DECISION DELEGATED TO HEAD OF PLANNING

Application No: H08-0333-25 **Applicant:** Miss C Southgate
Proposal: Change of use from agricultural land to equestrian, erection of stable block and riding arena
Location: Joanne Belnie Lane Gosberton
Terminal Date: 9th July 2025

Drawing 002 Scale 1:100 A4

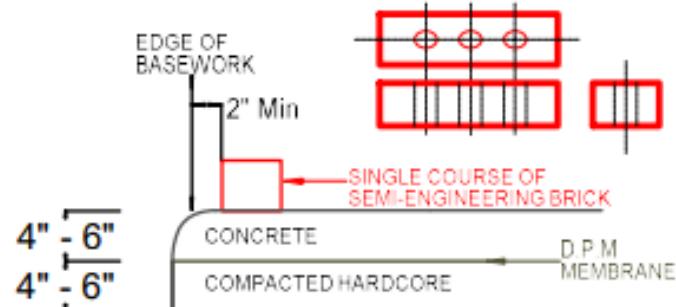
The proposed building will be located adjacent to the northern boundary of the site and whilst relatively large the structure is not of a significant height, the eaves and ridge being 2.25metres and 3.1metres respectively. Moreover, the siting of the building will be viewed in the context of the applicants' dwelling and neighbouring house and its impact on the wider landscape will be further mitigated through planting proposed to the north and west as part of Biodiversity Net Gain. The menage although visible is not considered intrusive and the proposed timber post and rail fence around the arena is an appropriate form of boundary treatment in a rural landscape.

Pre-Development Plan Baseline Map

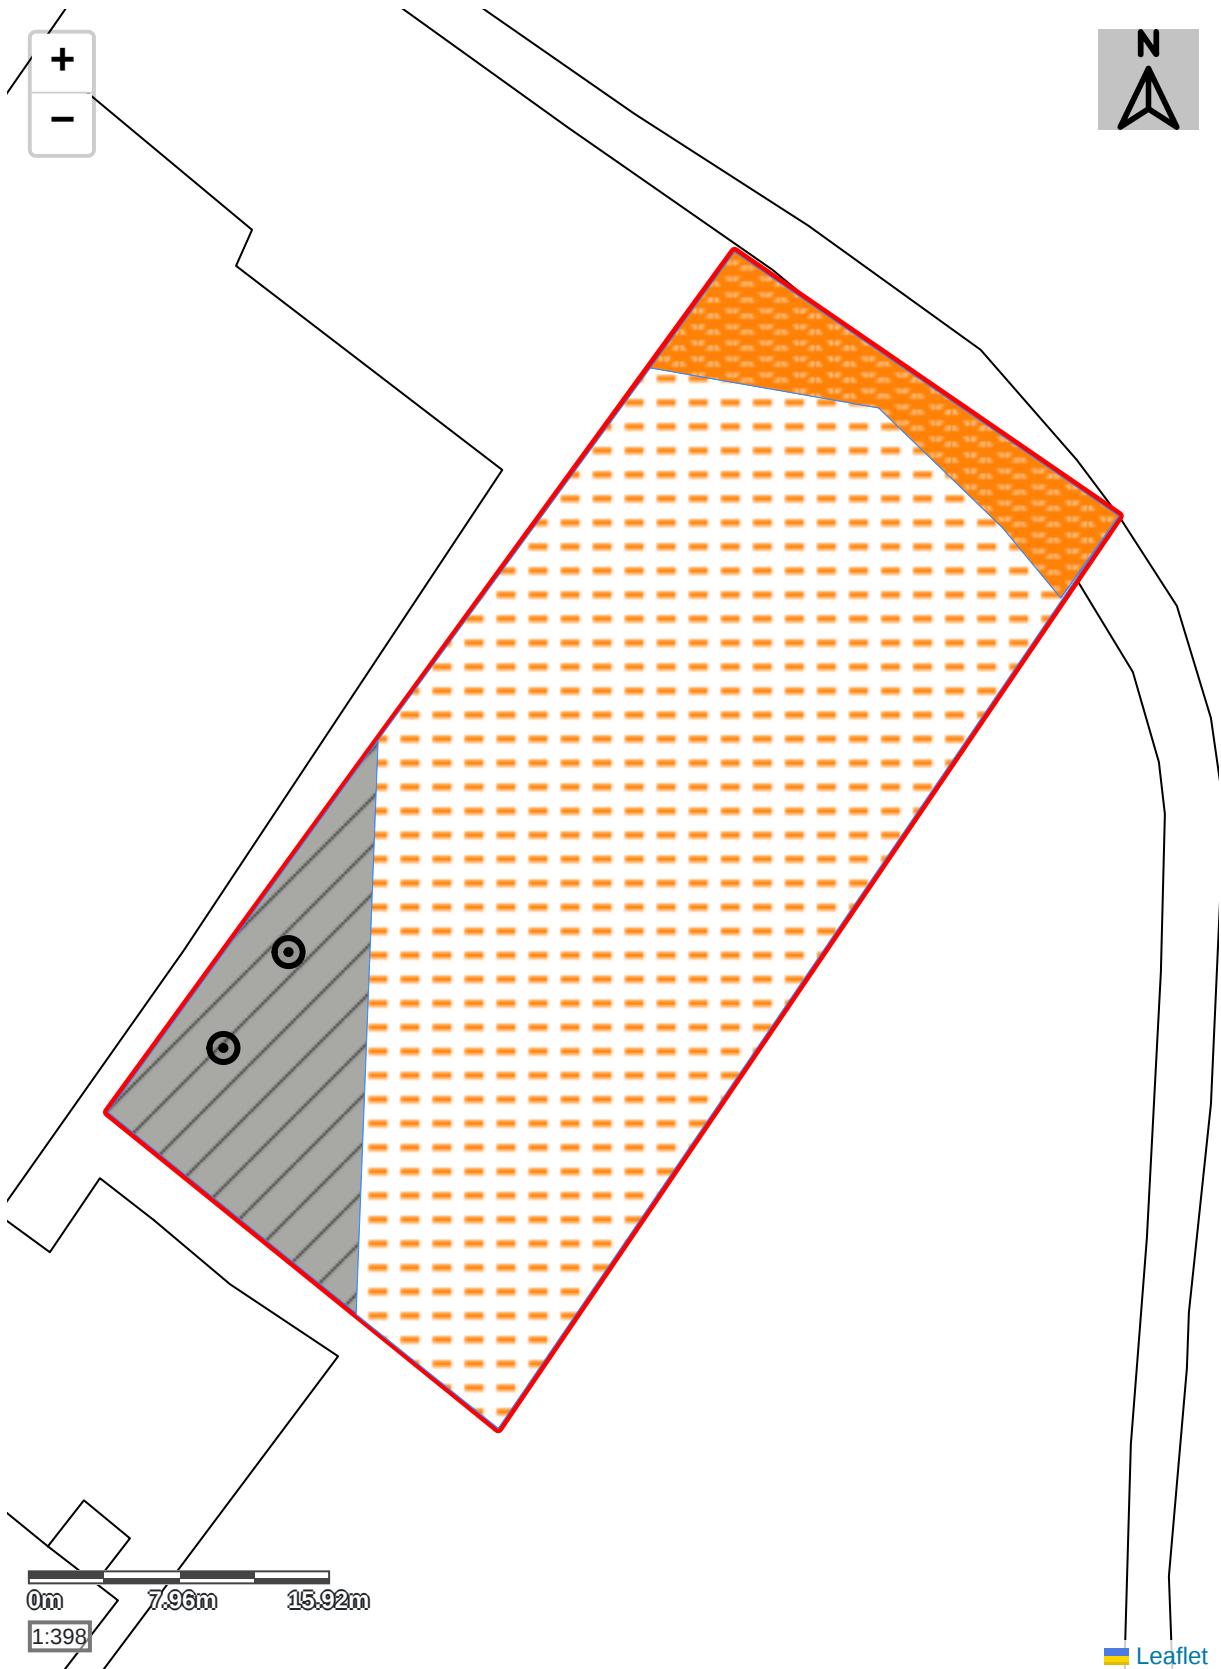
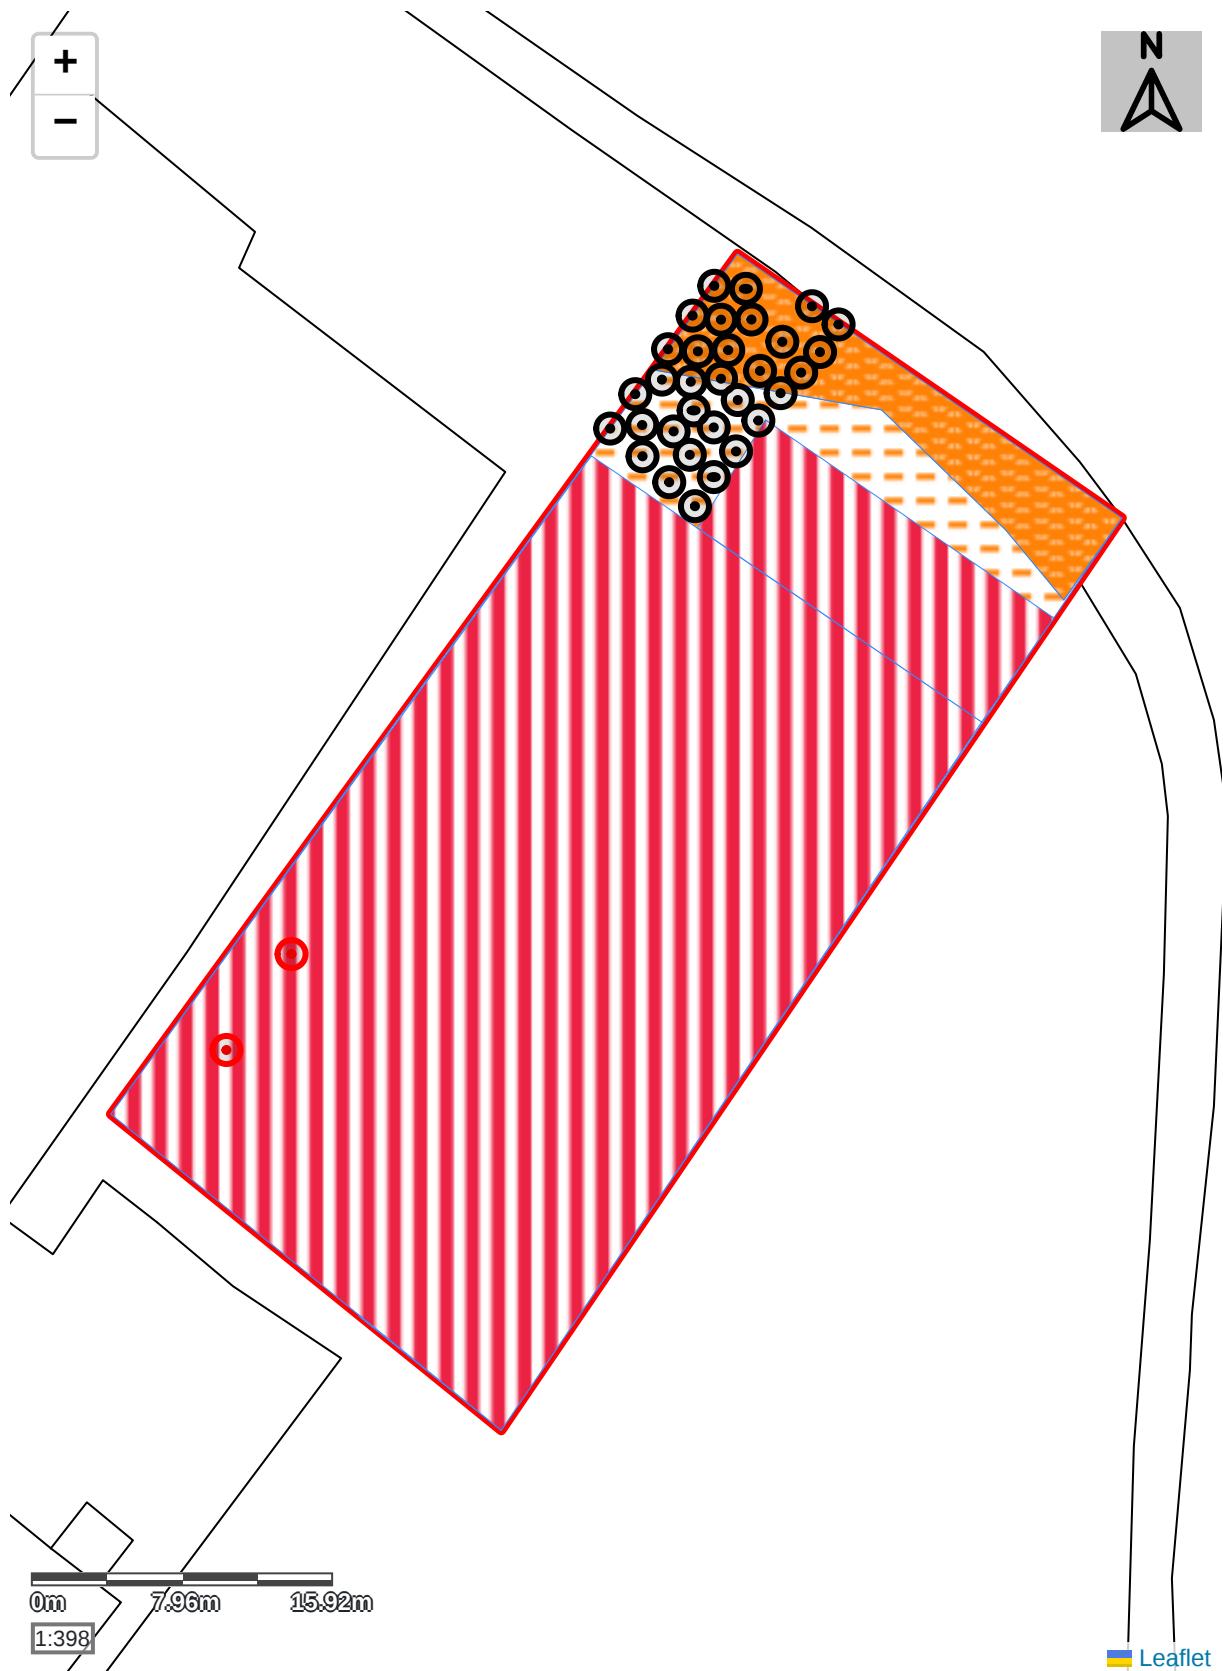
The Council's Ecologist advised there has been sufficient evidence provided by the applicant to be confident that the development will achieve 10% biodiversity net gain. However, the Ecologist advised that minor changes were required to both the metric and post development habitat plan, these were:

- 1) It appears on the baseline habitat map that there are two small trees within the ruderal/ephemeral habitat area. These trees will need to be added to the baseline metric. Even with these additions, 10% net gain will still be able to be achieved.
- 2) The tight spacing for new tree planting as suggested in the post-development map is unfeasible. For example, individual trees should be provided approximately 2.5 m of space if they are to grow to moderate condition. In this case, the proposed tree spacing appears to be a maximum of 1m apart. However, If the proposed trees were to be spaced out across the North Eastern border on the tussocky field margins and remaining cropland, there should be appropriate planting distance between trees. Any changes made to tree planting plans should be altered in the post-development habitat map and metric as appropriate.

An amended metric and post development habitat plan have been submitted by the applicant to accord with the requirements of the Council's Ecologist to ensure the development achieves the mandatory 10% biodiversity net gain.
